From: [Rich Elliott](#)
To: [Chace Pedersen](#)
Cc: [Dan Young](#); [Joe Delvo](#); [Dan Johnson](#); [Jeremy Haberman](#)
Subject: RE: [Ext] SP-23-00005 Craig - Notice of Application
Date: Tuesday, July 18, 2023 8:51:40 AM

SUBJECT: WDFW COMMENTS ON SP-23-00005 Craig

To: Chace Pedersen, CDS Planner I
From: Holly Erdman, B.S., Environmental Health Specialist II
Date: 8/2/23
RE: SP-23-00005 Craig

TO: All Staff
FROM: Public Works Plan Review Team
DATE: August 2nd, 2023
SUBJECT: Public Works Comments: SP-23-00005 Craig

SWEETWATER SHORT PLAT
PART OF SECTION 29, T. 19 N., R. 19 E., W.M.
KITTITAS COUNTY, WASHINGTON

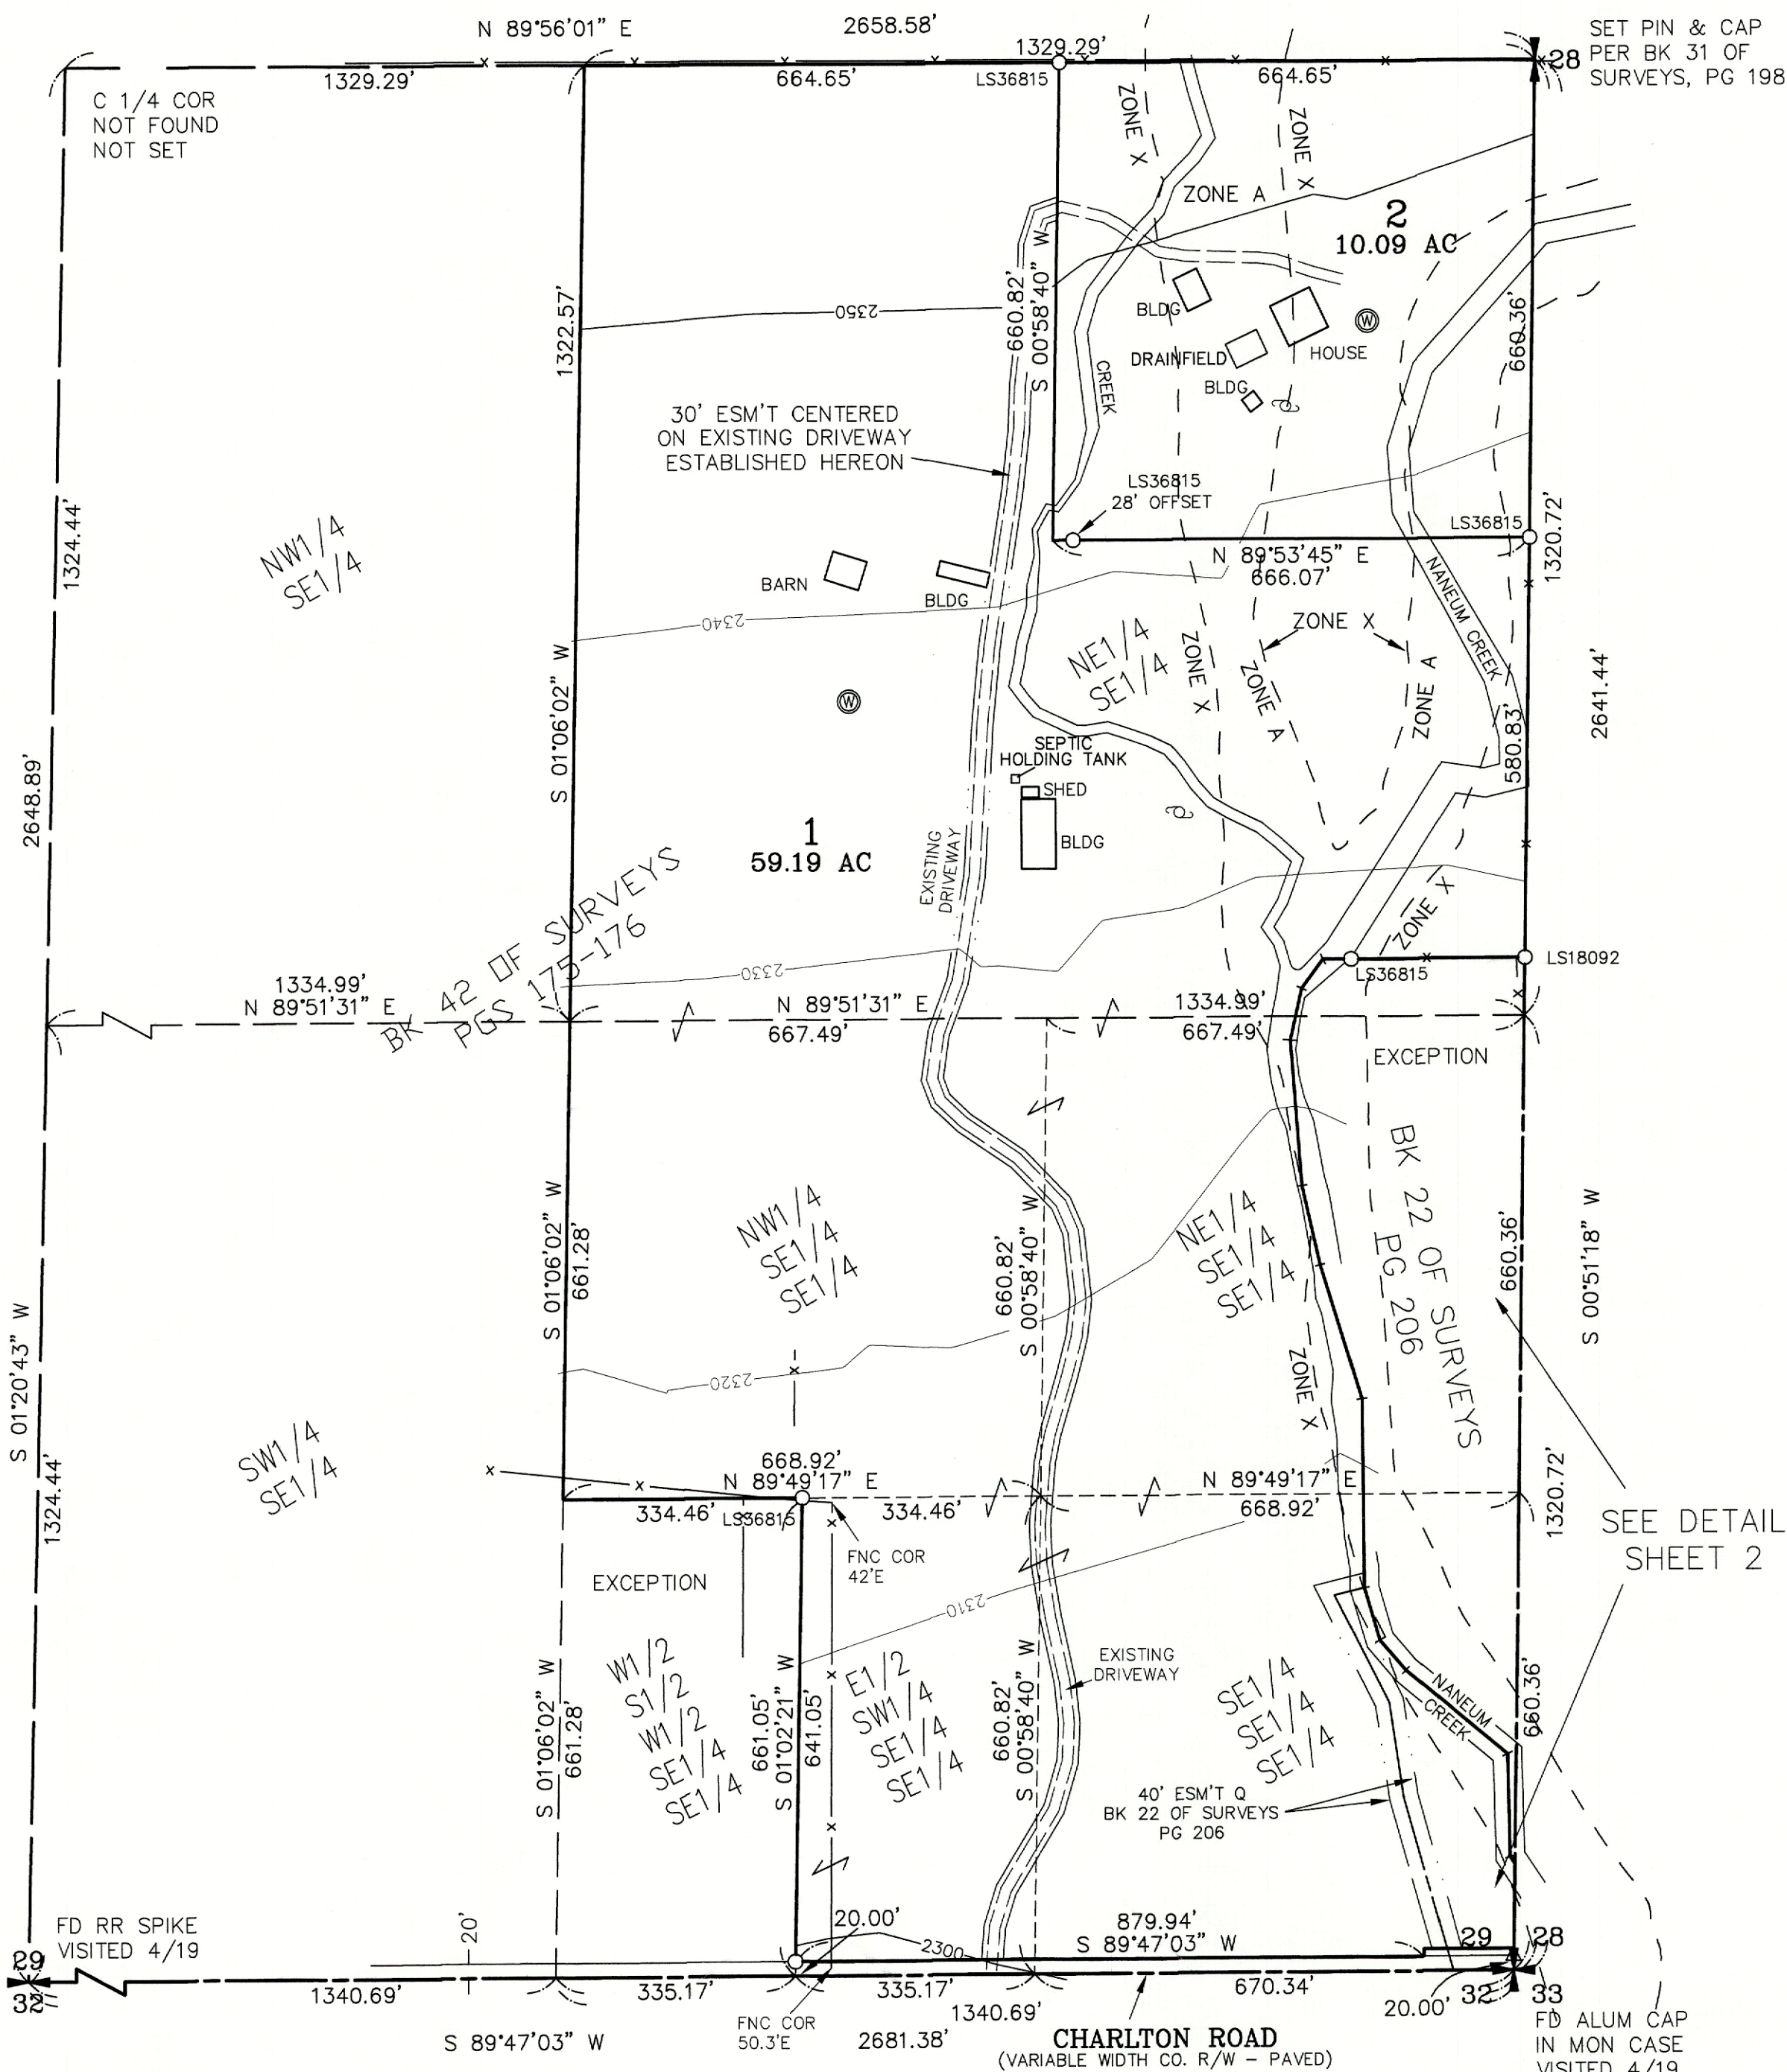
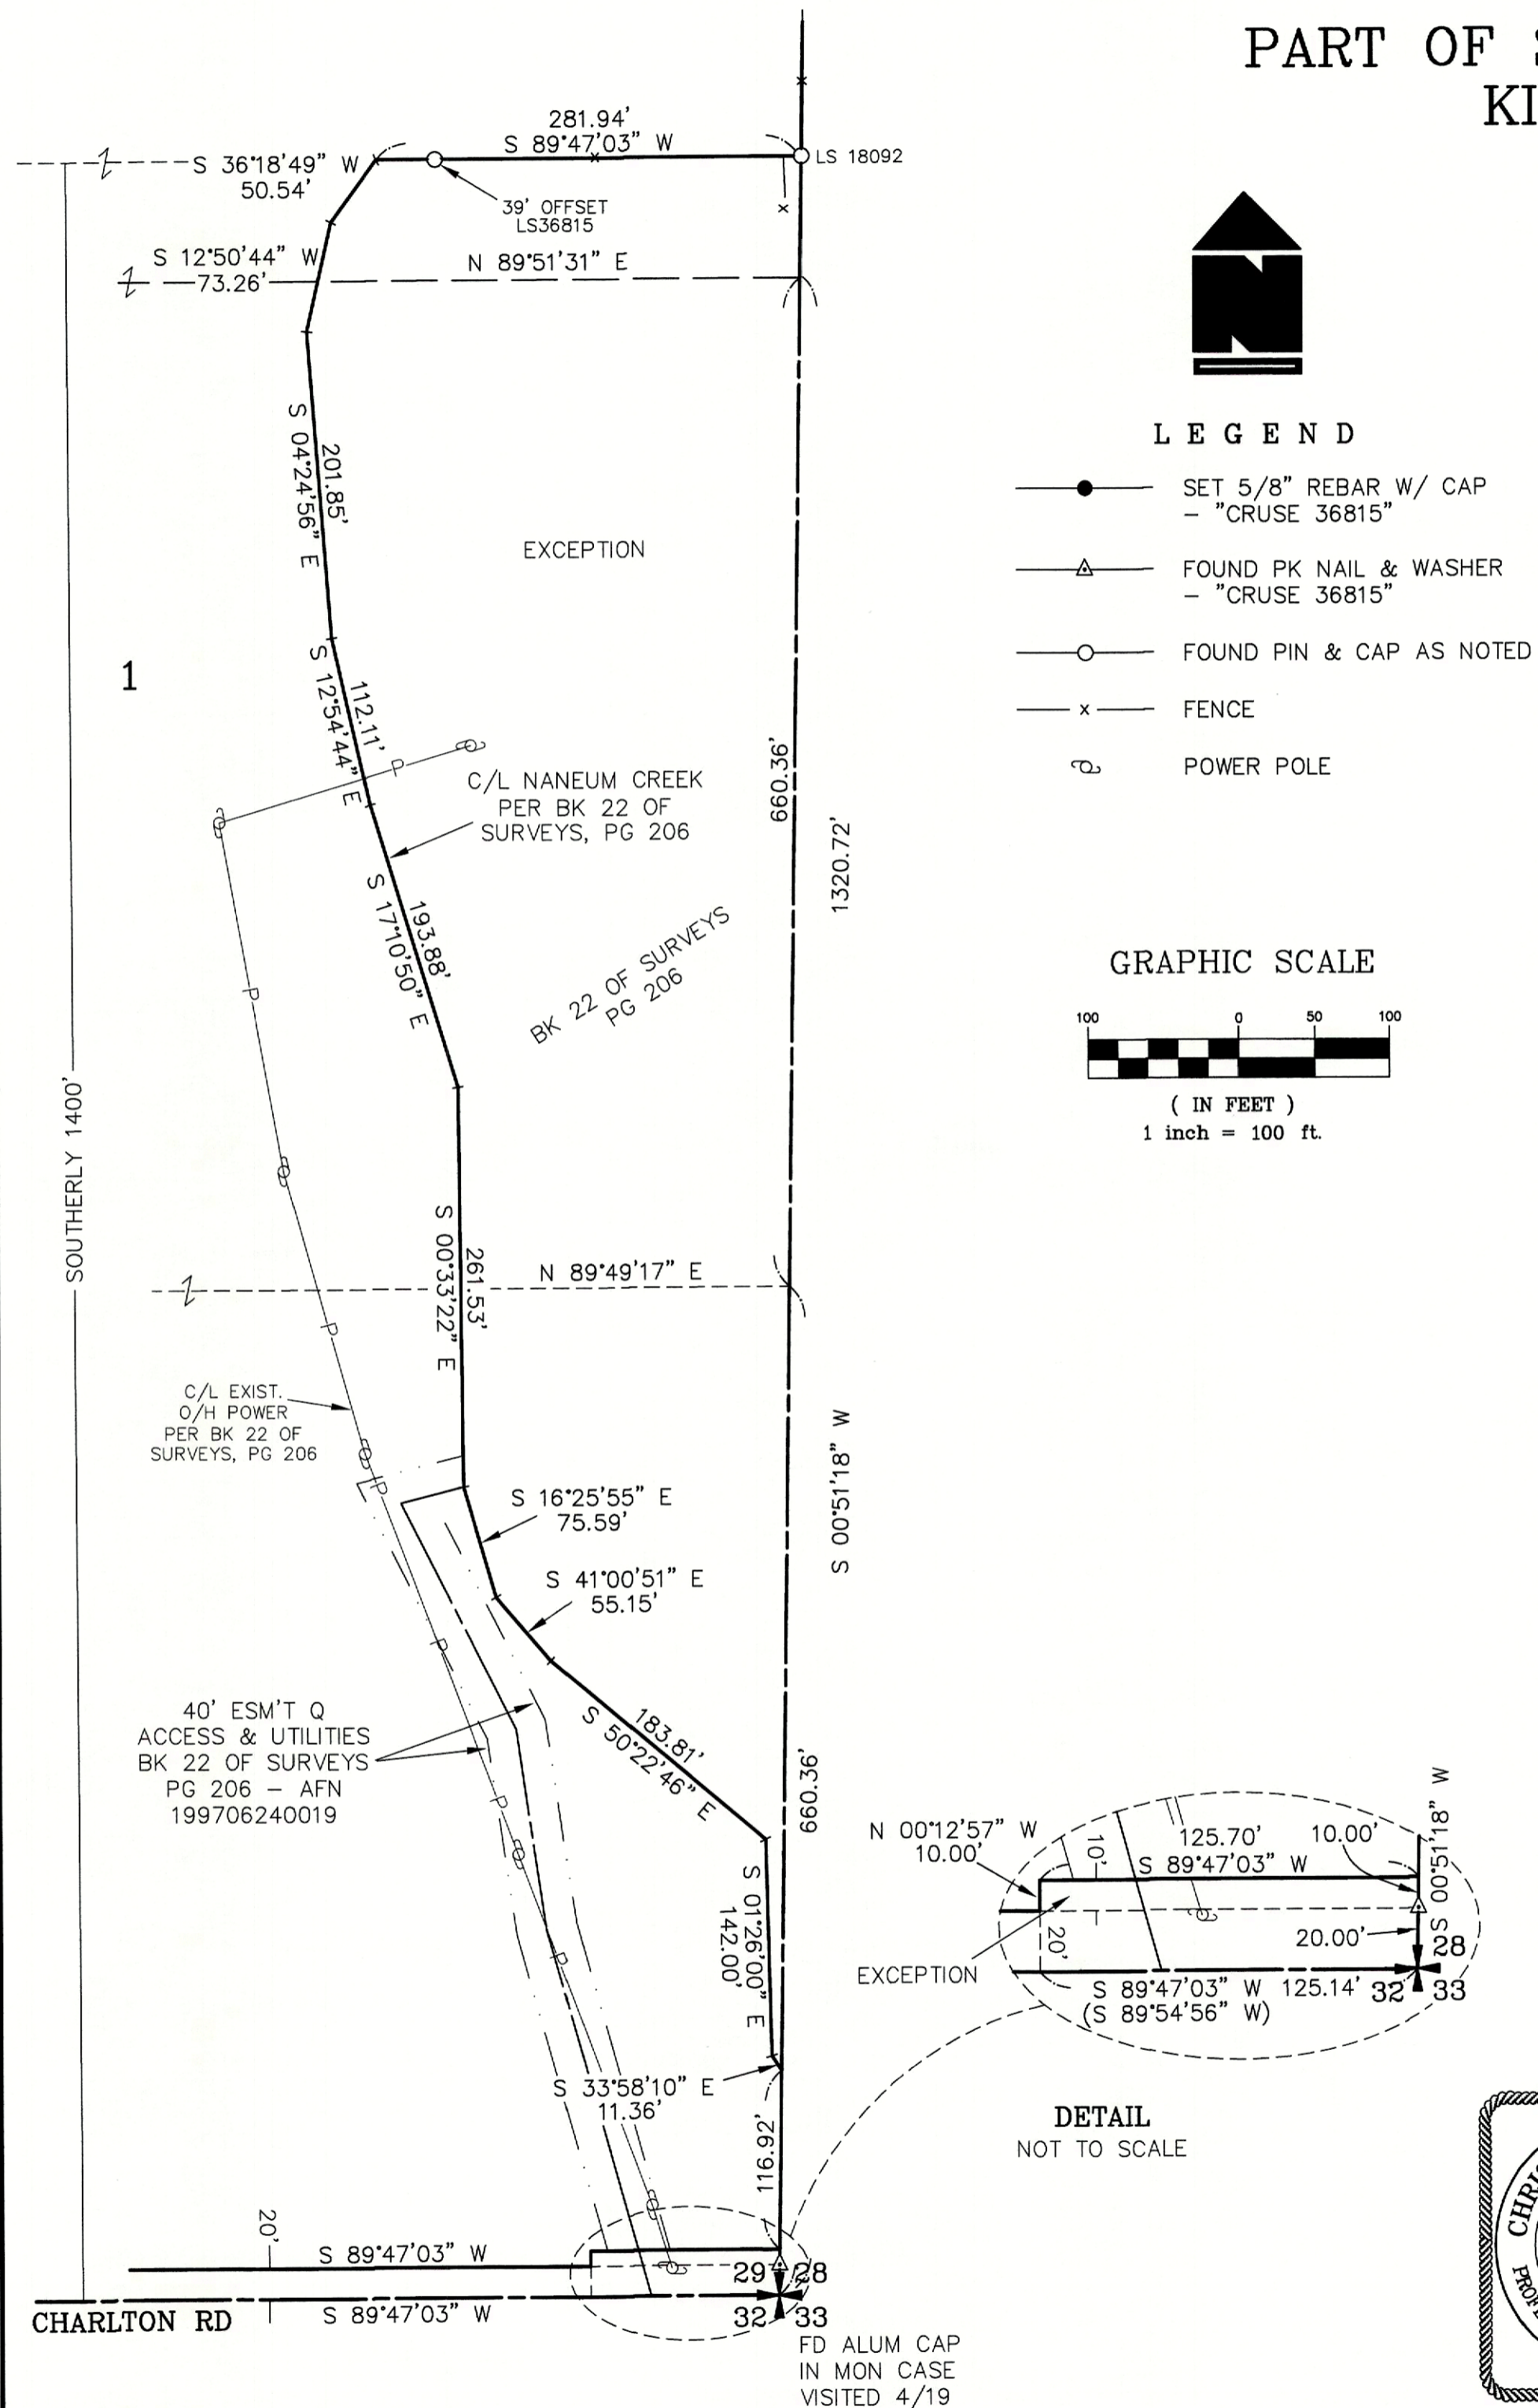
The proposed short plat drawing indicates there is an existing well on each proposed lot. The applicant indicates there will be an individual well and septic system on each lot. The applicant must prove legal and physical availability of water for all new uses of water on proposed lots.

A well log for the existing well on lot 1 must be submitted for review. Water rights are needed for lot 1.

While WDFW has no substantive objections to the short plat, we do want to comment on the potential impact of any future building on these parcels and their impacts to Fish and Wildlife Habitat Conservation Areas (FWHCA) under the Kittitas County Critical Areas Ordinance (CAO). In the northwest of the parcel is priority shrubsteppe habitat which is used by a variety of priority wildlife species, including but not limited to mule deer. In the eastern part of the parcel is Naneum Creek and its associated riparian area. Naneum Creek is an important fish-bearing stream and its associated riparian area supports a wide diversity of wildlife for breeding, wintering, and migration. Naneum Creek in this vicinity has characteristics of a Channel Migration Zone (CMZ) and the unnamed tributary referenced in the report is likely a side channel of Naneum Creek.

If the short plat is approved, WDFW would request that before any future building is approved in these critical areas that a review of these FWHCA be identified and either avoided or mitigated for as described in the Kittitas County CAO. WDFW would request to review such plans in an effort to help Kittitas County administer their CAO for FWHCA of which WDFW has extensive technical knowledge.

<p>FLOOD</p>	<p>Portions of parcels 558434 and 205736 are within the FEMA identified special flood hazard area (100-year floodplain) zone A. If possible, any future development should occur outside of the floodplain in order to reduce risk and avoid mandatory flood insurance purchase requirements. All activities within the floodplain must be permitted through the floodplain development permit process and follow the regulations within KCC 14.08.</p> <p>In accordance with KCC Chapter 14.08.220, All subdivisions as well as new development shall:</p> <ol style="list-style-type: none"> 1. Be consistent with the need to minimize flood damage. 2. Have public utilities and facilities such as sewer, gas, electrical, and water systems located and constructed to minimize flood damage. 3. Have adequate drainage provided to reduce exposure to flood damage. 4. Where base flood elevation data has not been provided or is not available from another authoritative source, it shall be generated for subdivision proposals and other proposed developments containing greater than 50 lots or 5 acres (whichever is lesser) and shall be included as part of the application and shall be noted on the final mylar. 5. All subdivisions shall show on the face of both the preliminary and final plat, for either short or long plats, the boundary of the 100year floodplain and floodway. <p>Since the parcels are located in zone A, KCC 14.08.220(4) is applicable. Please contact the Floodplain Administrator at 509-962-7523 for assistance.</p>
